KIRKLEES METROPOLITAN COUNCIL INVESTMENT & REGENERATION SERVICE

DELEGATED DECISION TO DETERMINE APPLICATIONS FOR NON-MATERIAL AMENDMENTS

Reference No: **2026/NM/92032/W**

Description: Non material amendment to previous permission
2024/92647 for erection of detached dwelling with
detached garage

Drawing title
Garage Floor Plan and Elevations as Proposed

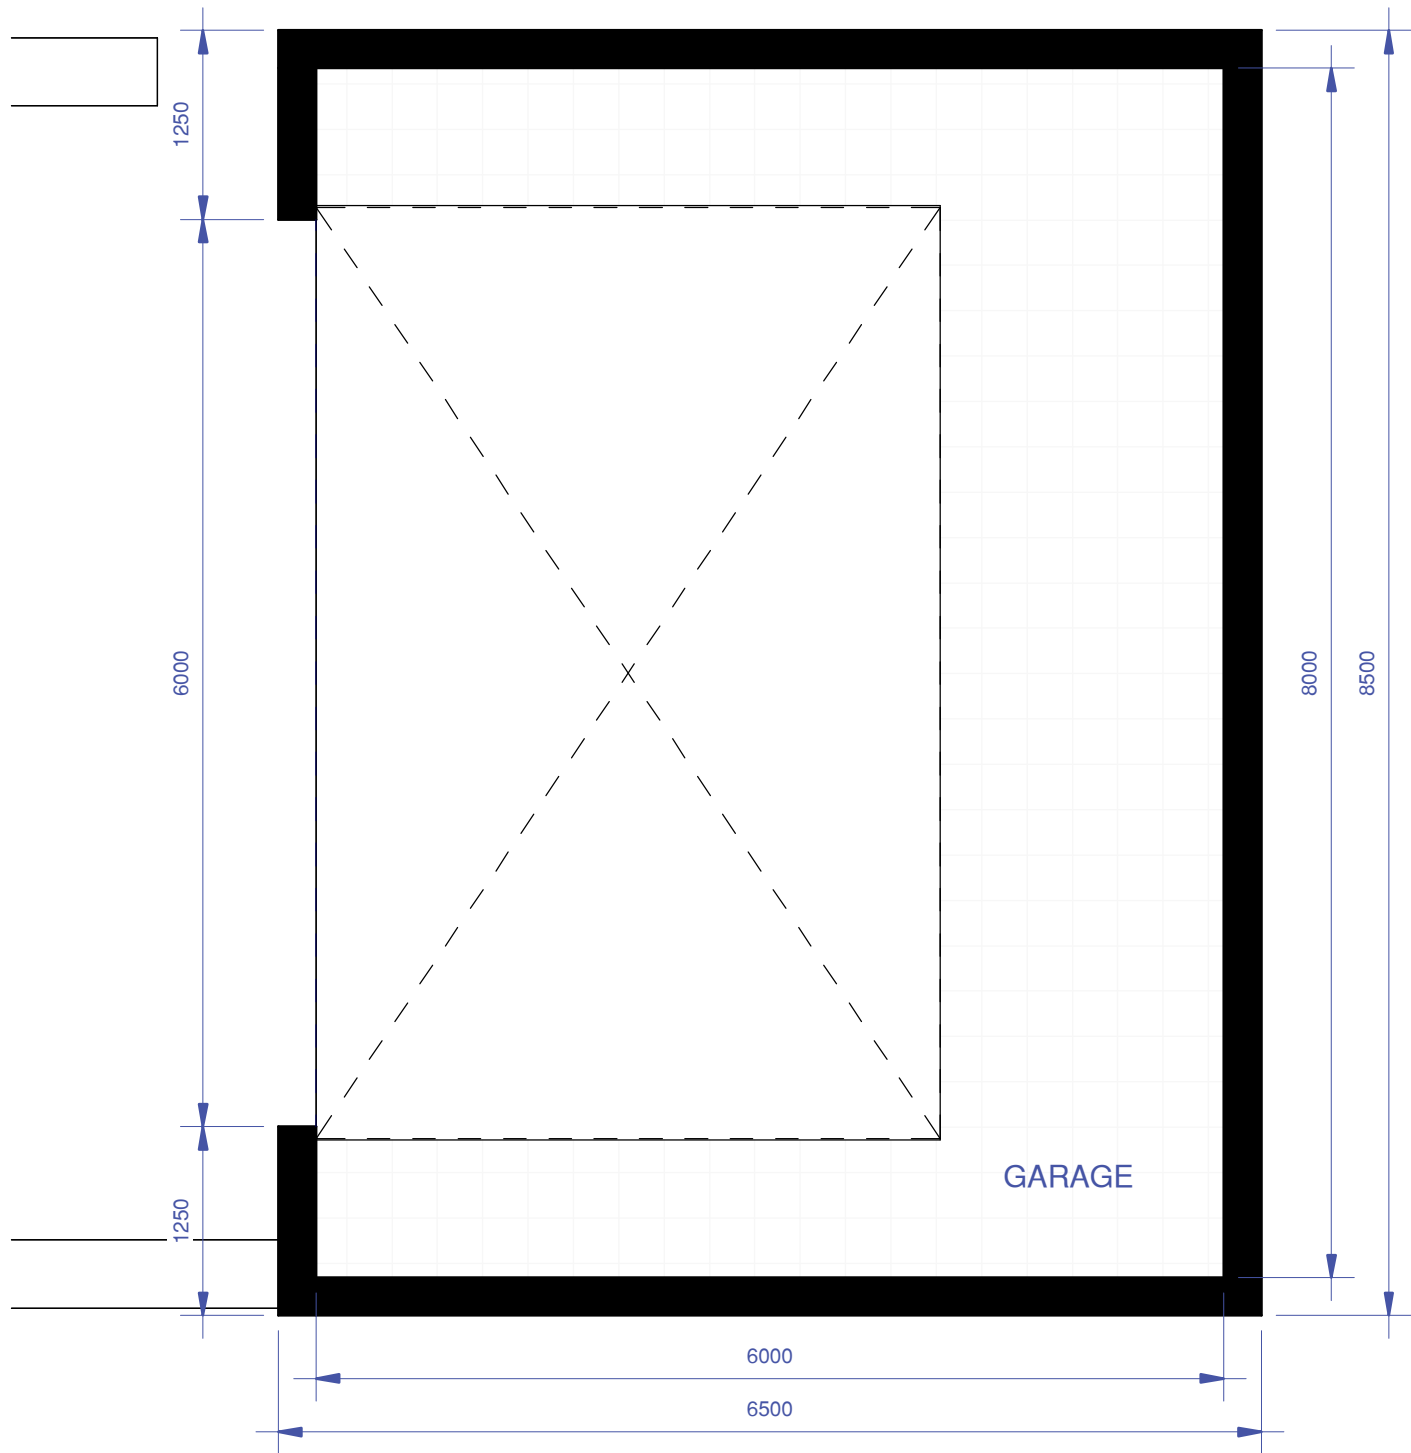
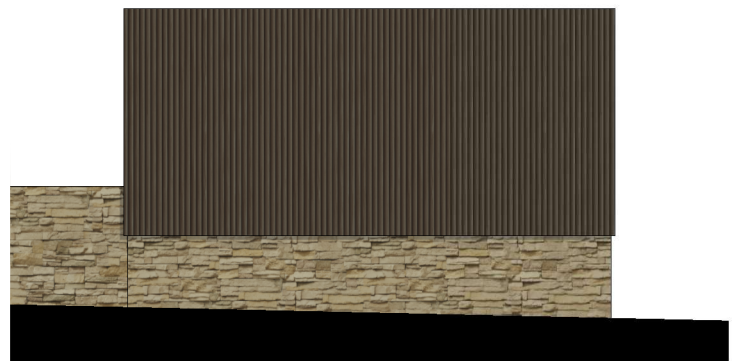
- The garage is increasing by 31% which is not minor
- Emergency and service-vehicle access would be affected by the proposal
- The alterations affect driveway / legal access, the boundary wall and stability of land beside the excavation; underground services and drainage and potential of construction being on third party land.

The associated increase in the rear garden area and the increase in the floor space of the approved detached garage to accommodate additional vehicles and provide private amenity space, would alter the scale and extent of the development as originally approved, as the proposed would see the movement of the proposed garage into an area originally designated for planting. In addition the proposal would see the dwellings size altered. Taken together, these changes are not considered to be inconsequential and would result in a development that differs materially from that granted planning permission. As such, the proposed amendments fall outside the scope of Section 96A of the Town and Country Planning Act 1990 and cannot be approved as a non-material amendment.

The proposed seeks approval for an increase in the floorspace of the detached garage for additional parking and amenity use and lengthening the garden. Alterations to the dwellings size would require small alterations in relation to its siting. Access arrangements for the garage would be slightly altered. The proposed changes would alter the size and form of the approved building and have the potential to affect matters relating to the relationship with neighbouring properties, including the effectiveness of boundary treatments, privacy and the wider impacts previously assessed in the original application.

Drawing title
Bungalow Floor & Roof Plans as Proposed

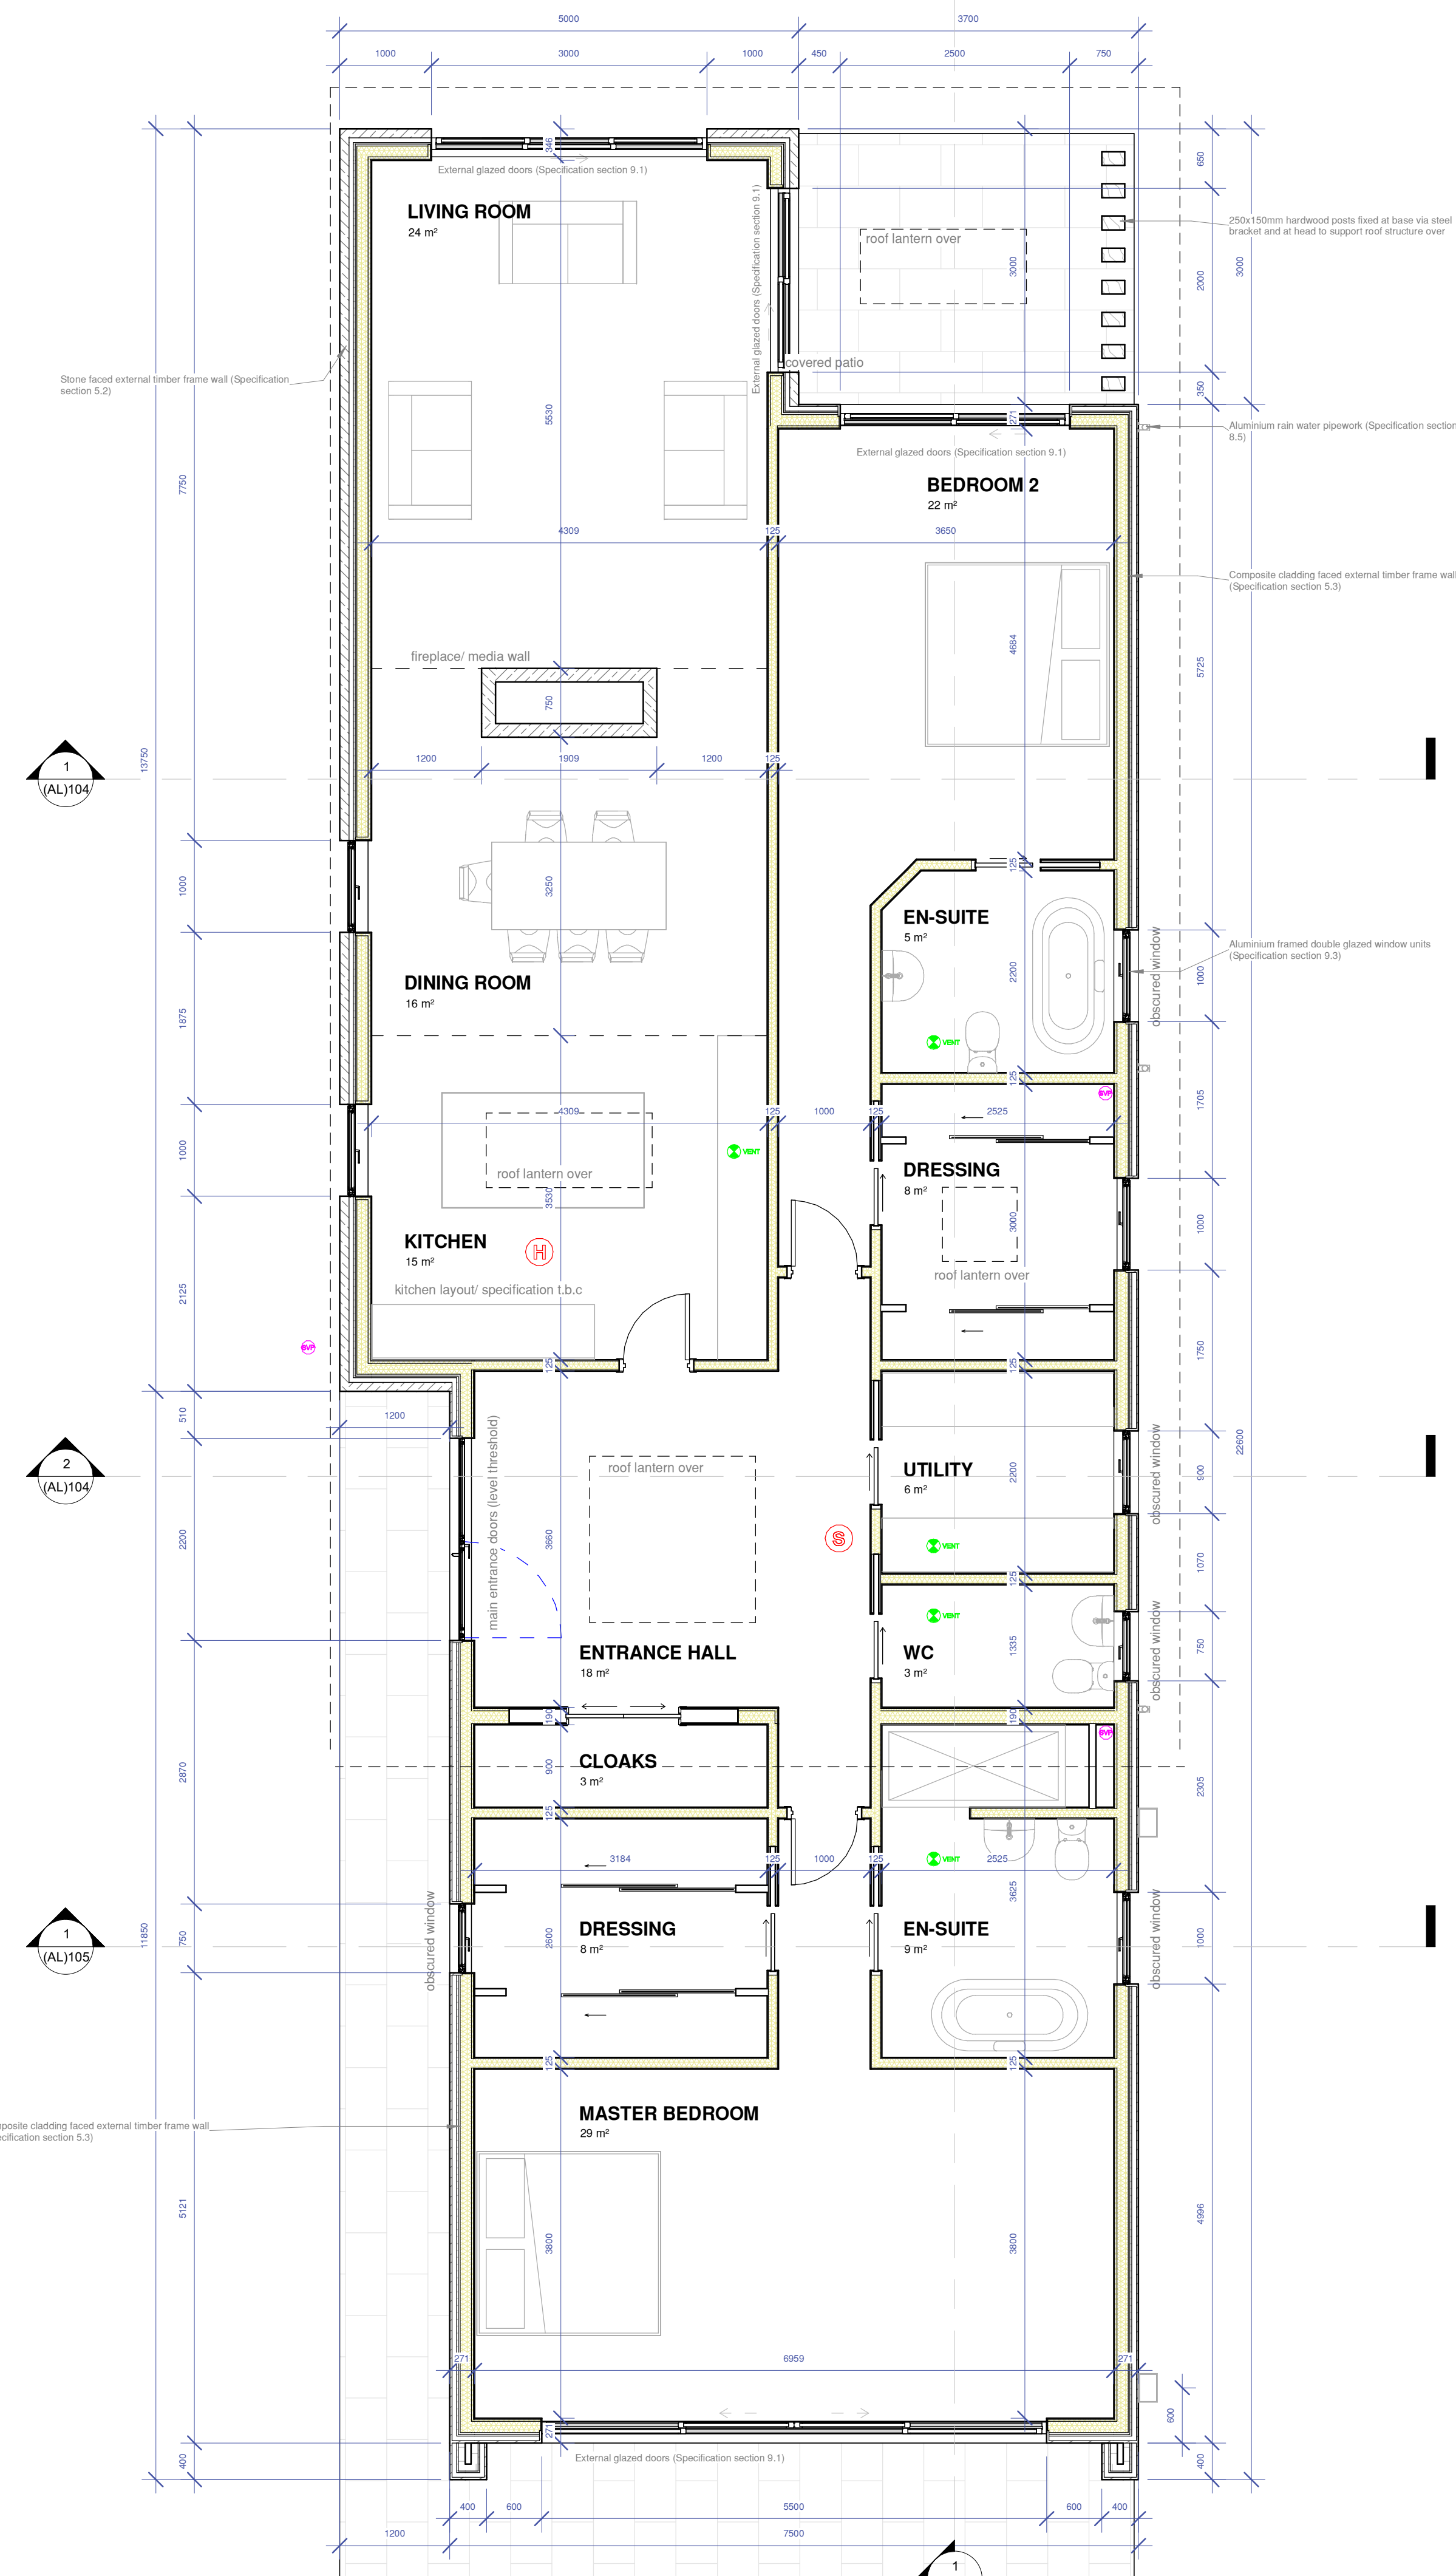
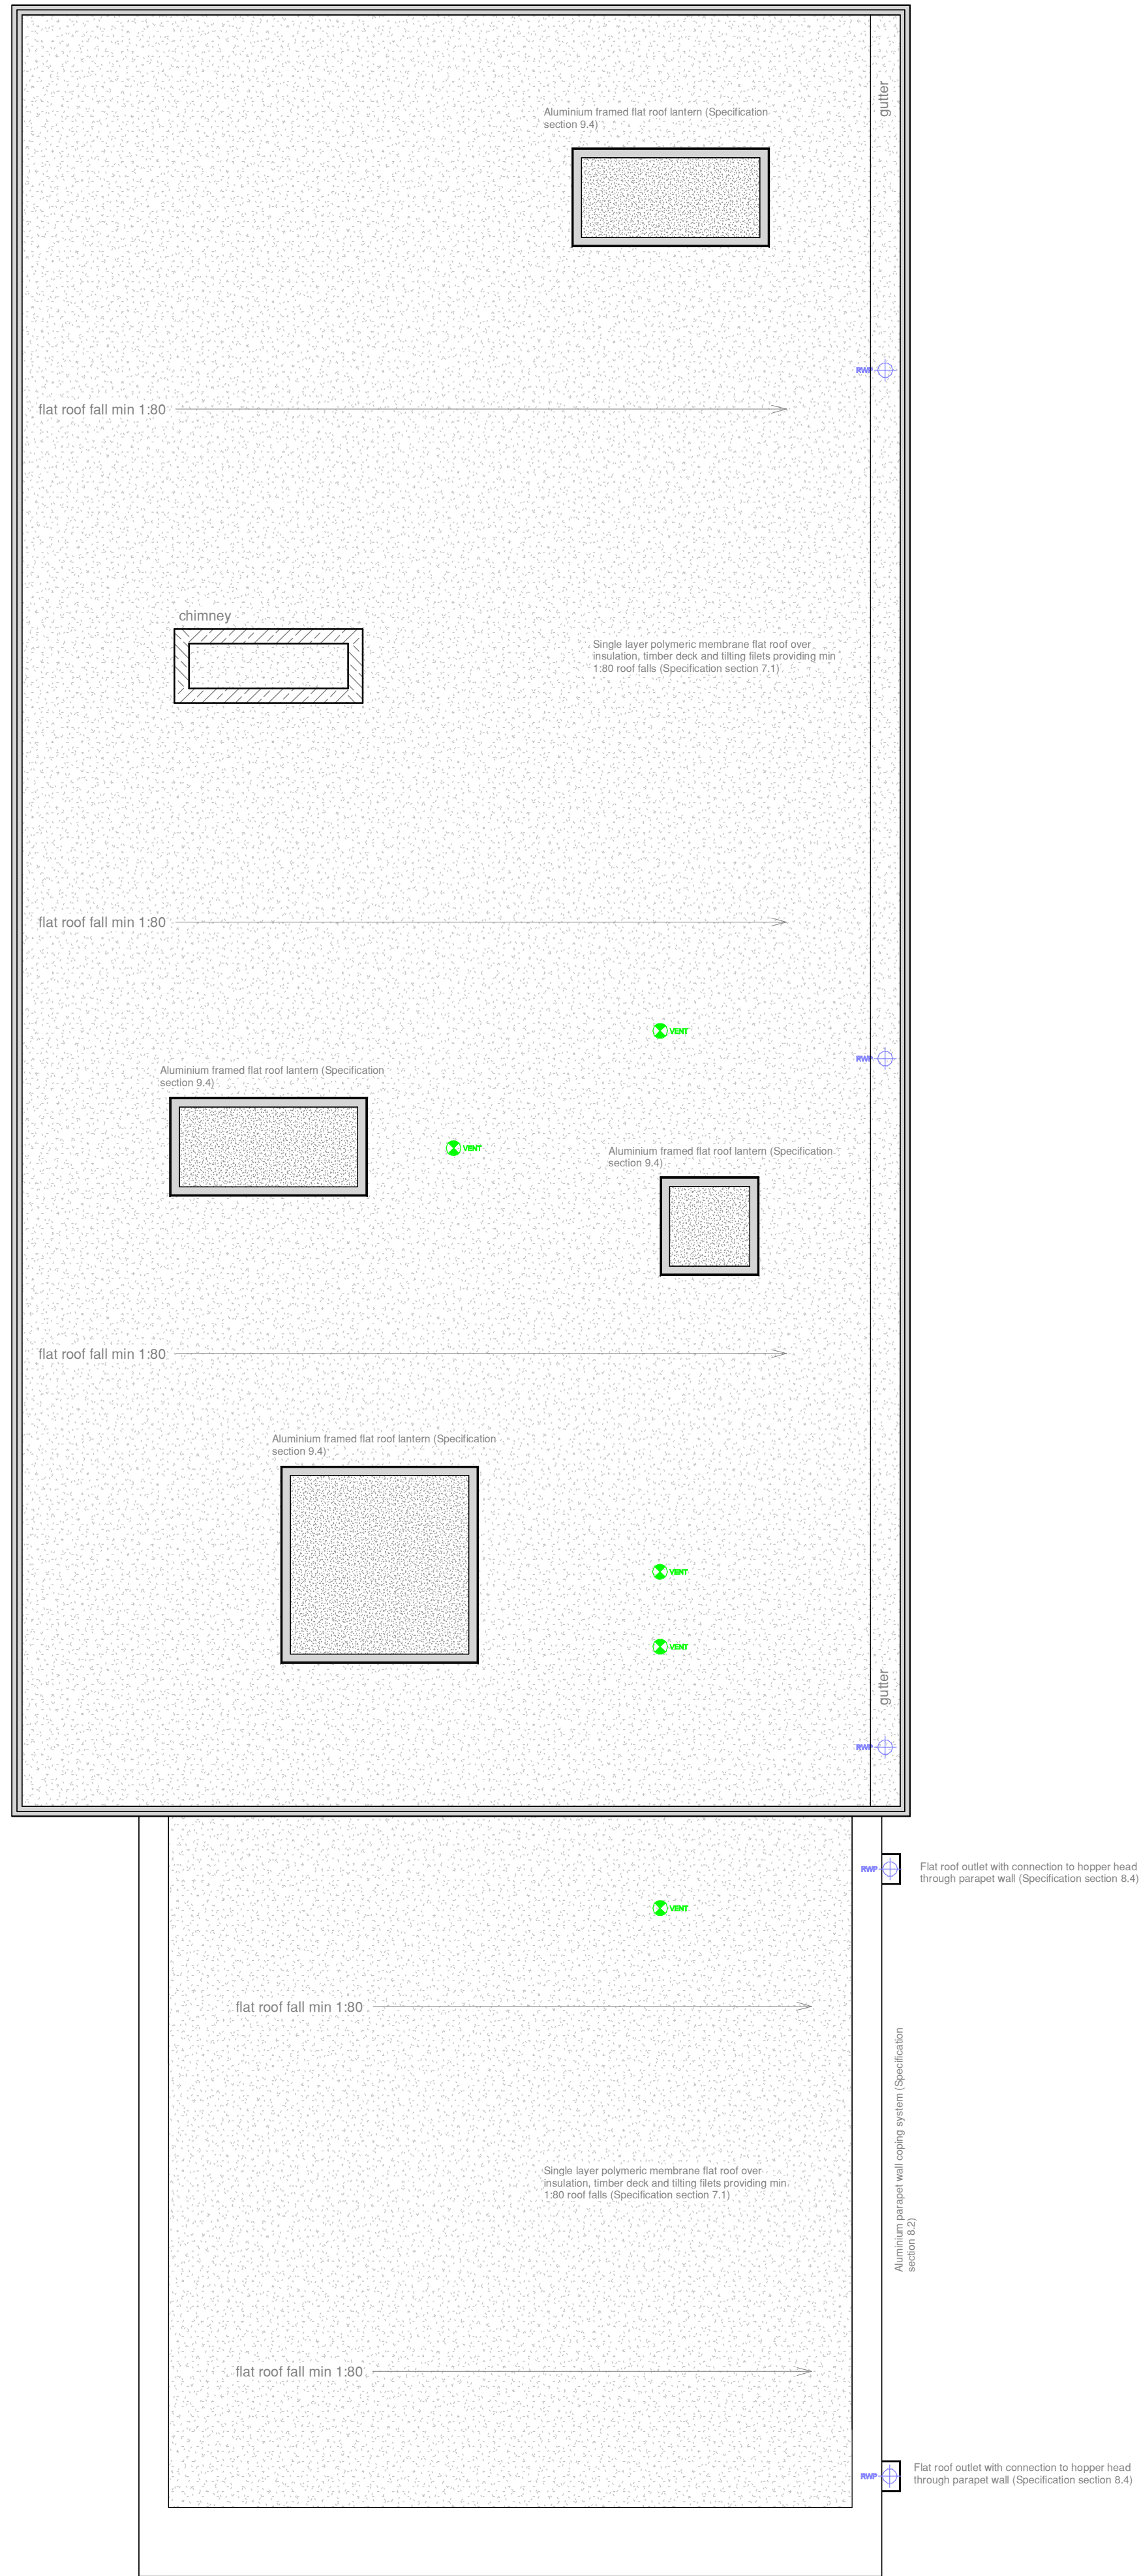
Comment: The proposed change would result in a material increase in height, scale, width or depth of a building.
